REVIEW COMMENTS

Project:		NM 335.01 Gibson & 98th St Gas Station		PDE:		
Review:				Reviewer:		
Date:		12/12/2022		Matt Grush, P.E.		
#	PAGE	SECTION	COMMENT	AGENCY	STATUS	RESPONSE
1	2	Introduction (Figure 1)	Locate Driveway B as far east as practicable. This will improve the access to the westbound leftturn lane at 98 th St and provide space for future lengthening of the right-turn lane.	COA	Agree	Accepted see new site plan included as Figure 1
2	2	Introduction	Relocate Driveway A to the north limits of the development	COA	Evaluate	The location of driveway A is fixed as an existing access point. This access point is an existing access easement.
3	48	Development Site-Specific Observations and recommendations	Add a right-turn lane [Driveway A], the length may be less than the DPM requirement. The City may accept a reduced length of the turn lane. Provide a short discussion on the effectiveness of the modified turn lane.	COA	Agree	A right-in / right-out driveway with a right-turn deceleration lane has been added to the site plan located south of driveway A. A discussion of the deceleration's effectiveness has been added to the body of the report.

RIGHT TURN DECELERATION LANE
SCALE: 1" = 10'

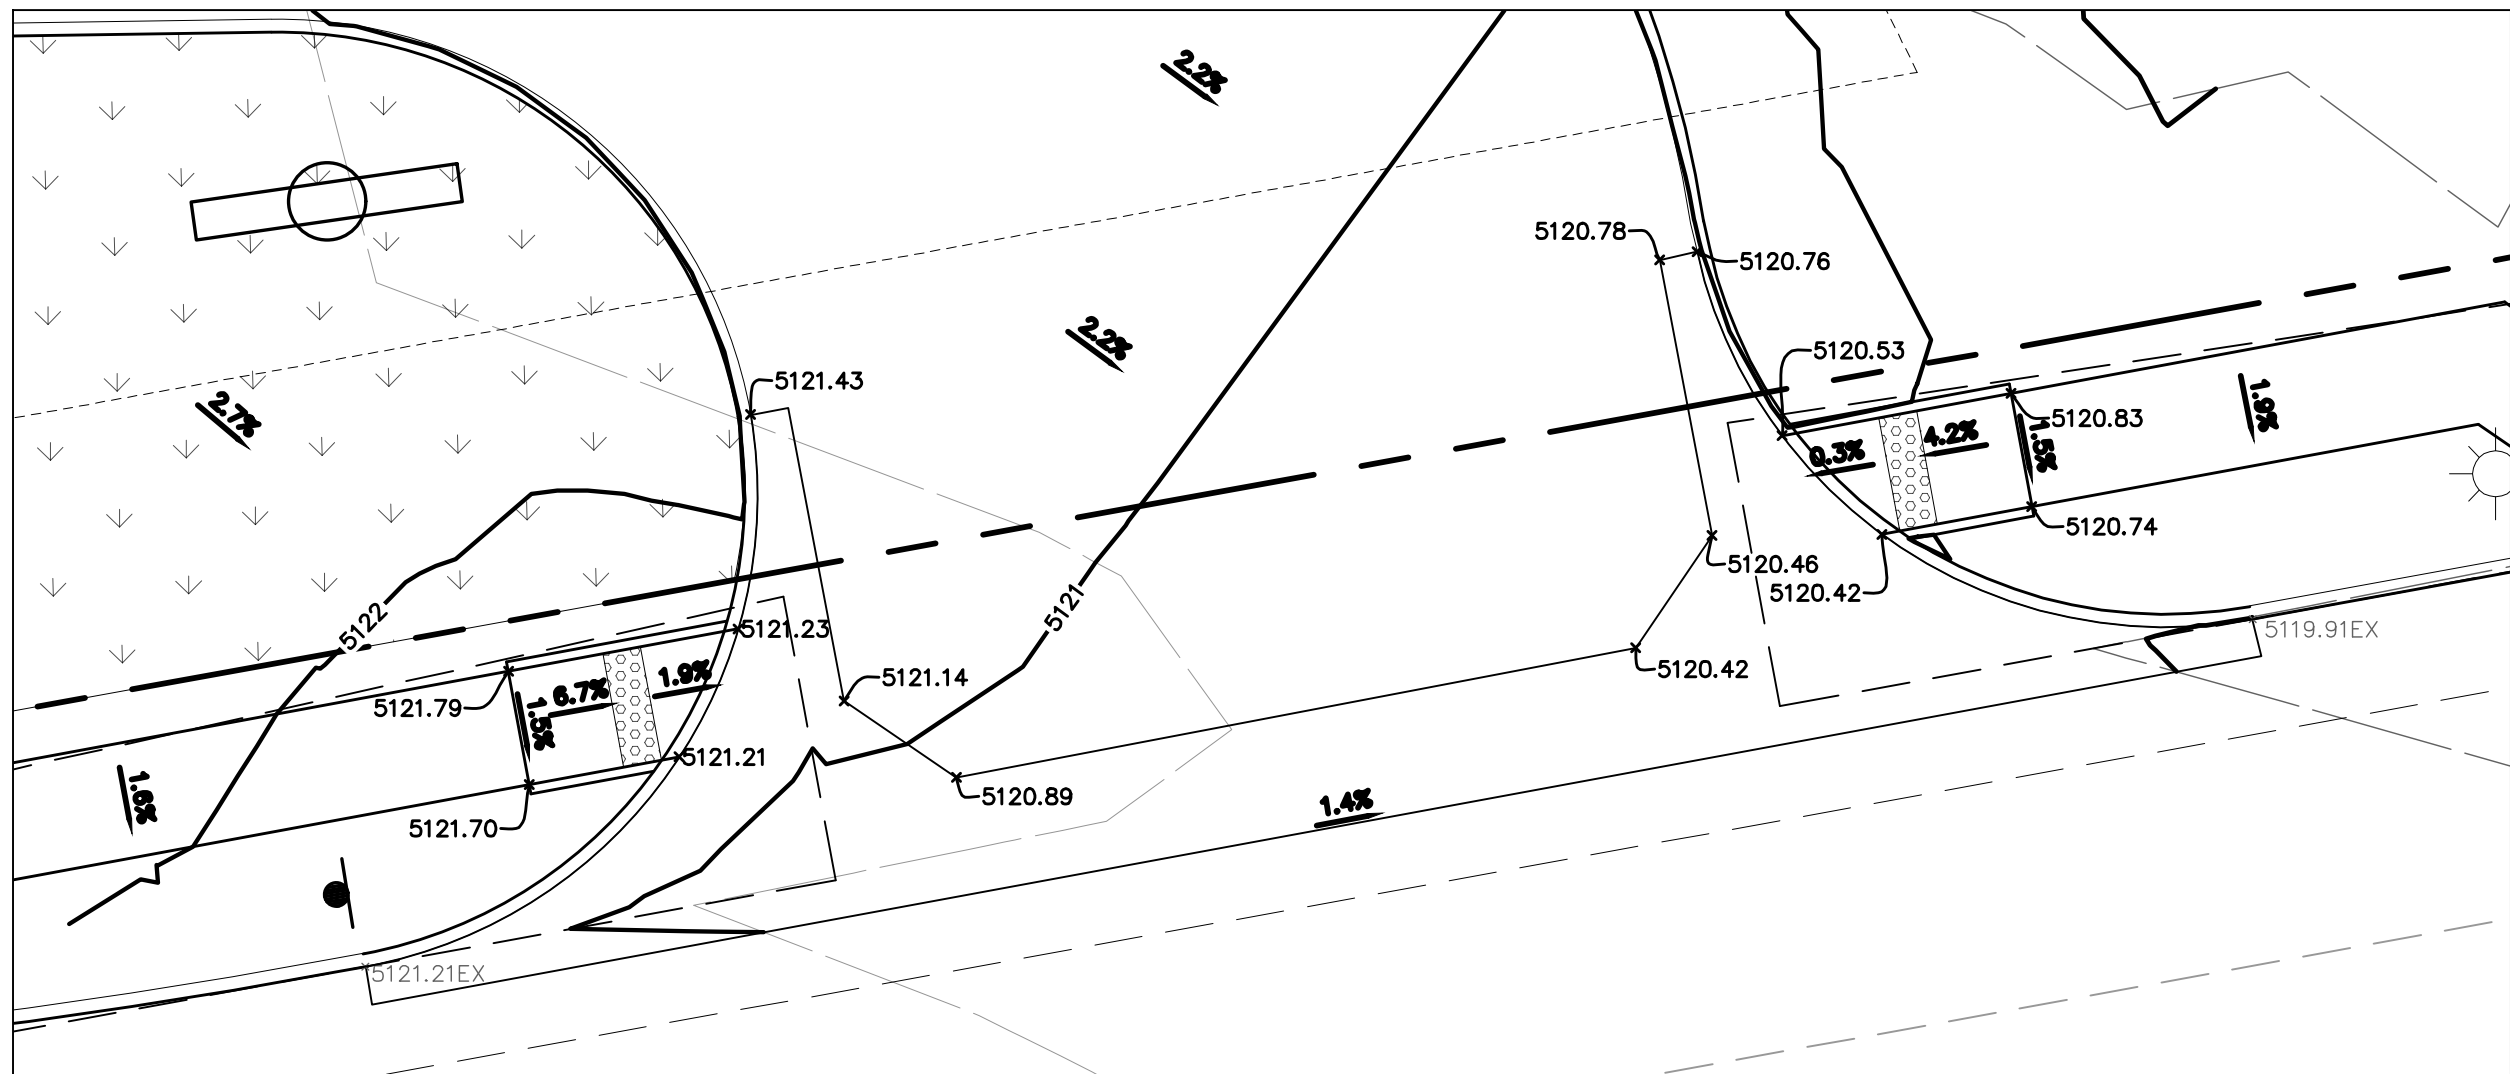
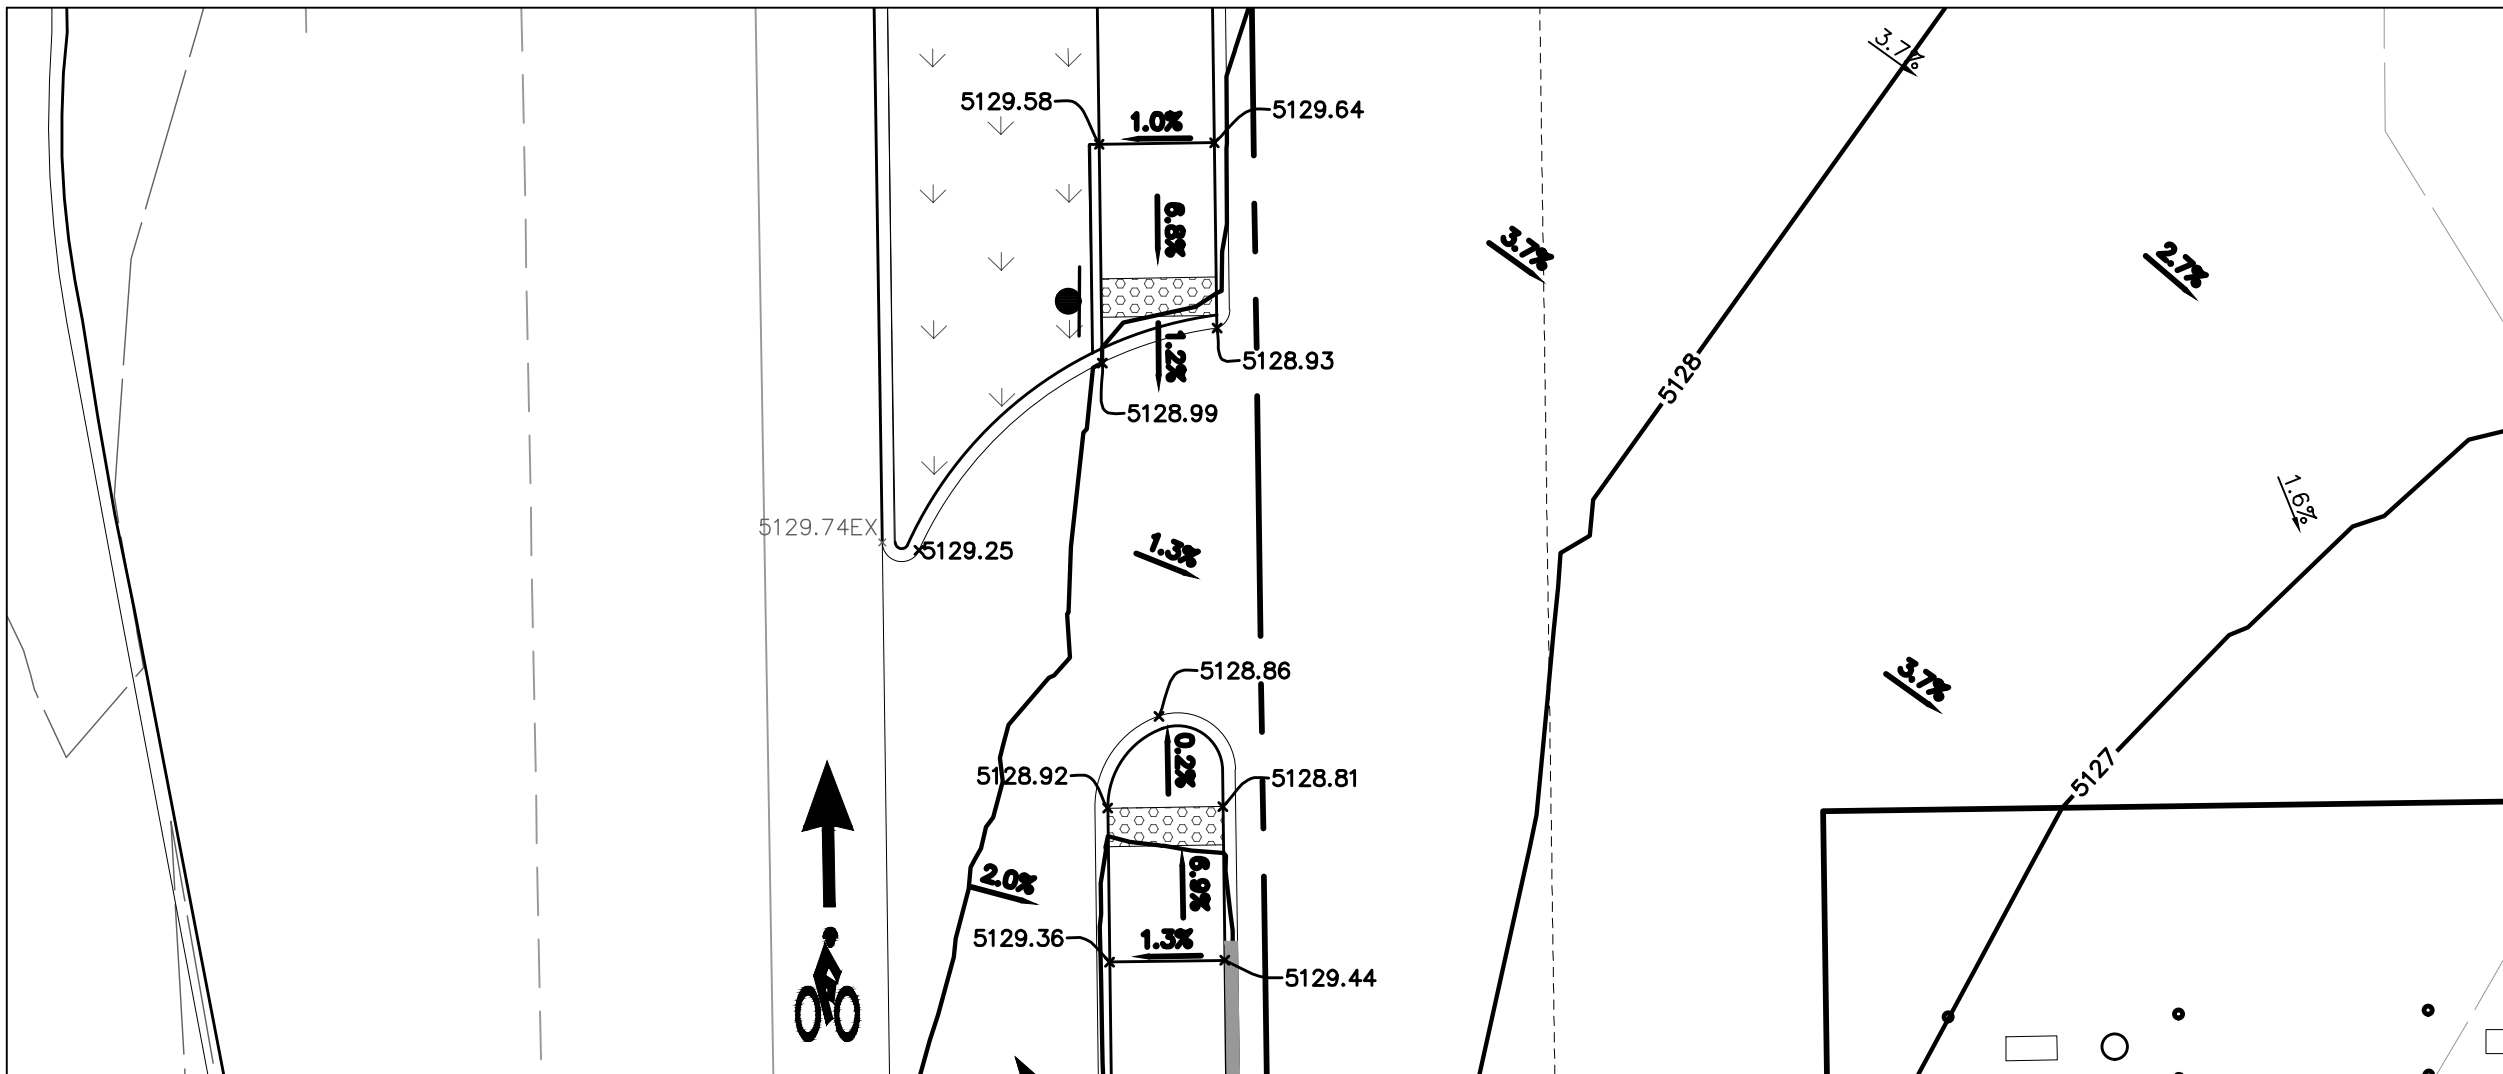
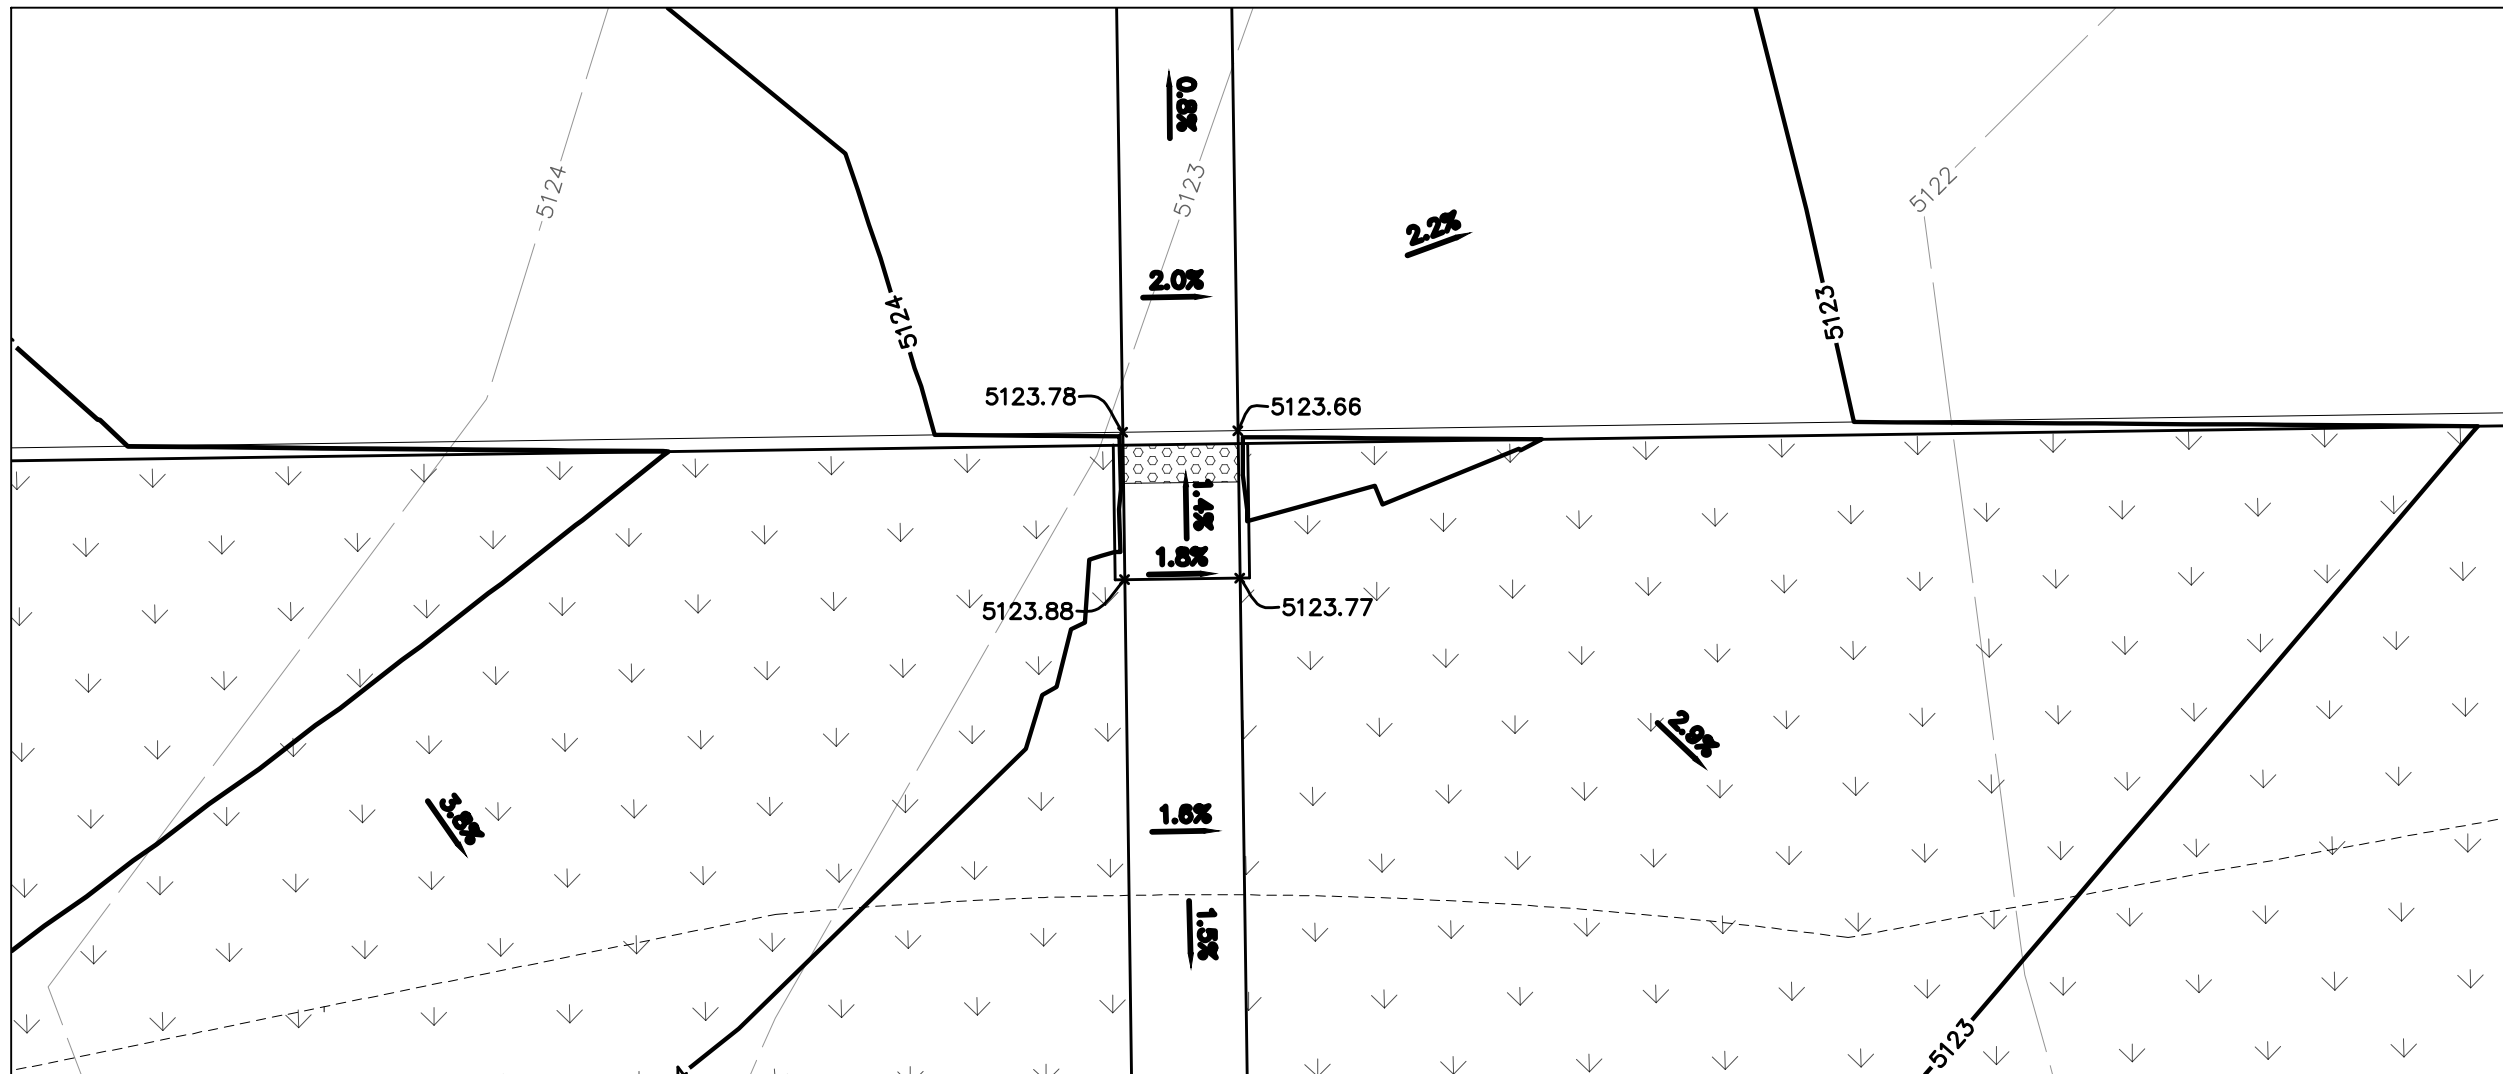
4	2	Introduction (Figure 1)	The transit stop should remain as is. The northbound right-turn lane can begin immediately north of the transit shelter.	COA	Agree	Accepted: This configuration is reflected in the newest site plan included as Figure 1
5	2	Introduction, Development Site-Specific Observations and recommendations	The access to the PNM facility should remain. Add a notification sign that this driveway is for PNM access only/dead end or what you feel is needed to discourage erroneous use of this driveway. The developer should coordinate with PNM concerning this driveway.	COA	Agree	No-Right turn sign added to driveway.
6	3	Summary of Recommendations	Summary of recommendations on page 3 describes Driveway A as right-in only. The analysis has this as a partial right-in/right-out. Please correct this to be a partial right-in/right-out access	COA	Evaluate	The summary of recommendations describes Driveway A as a Full Access driveway. The developer has since added a driveway to function as a right-in / right-out south of Driveway A on 98th St. This configuration change would make Driveway A a Left-in/ Left-out access point. Signing for both Driveway A and the new right-in/right-out driveway just south of it is shown in the new site plan shown in Figure 1.
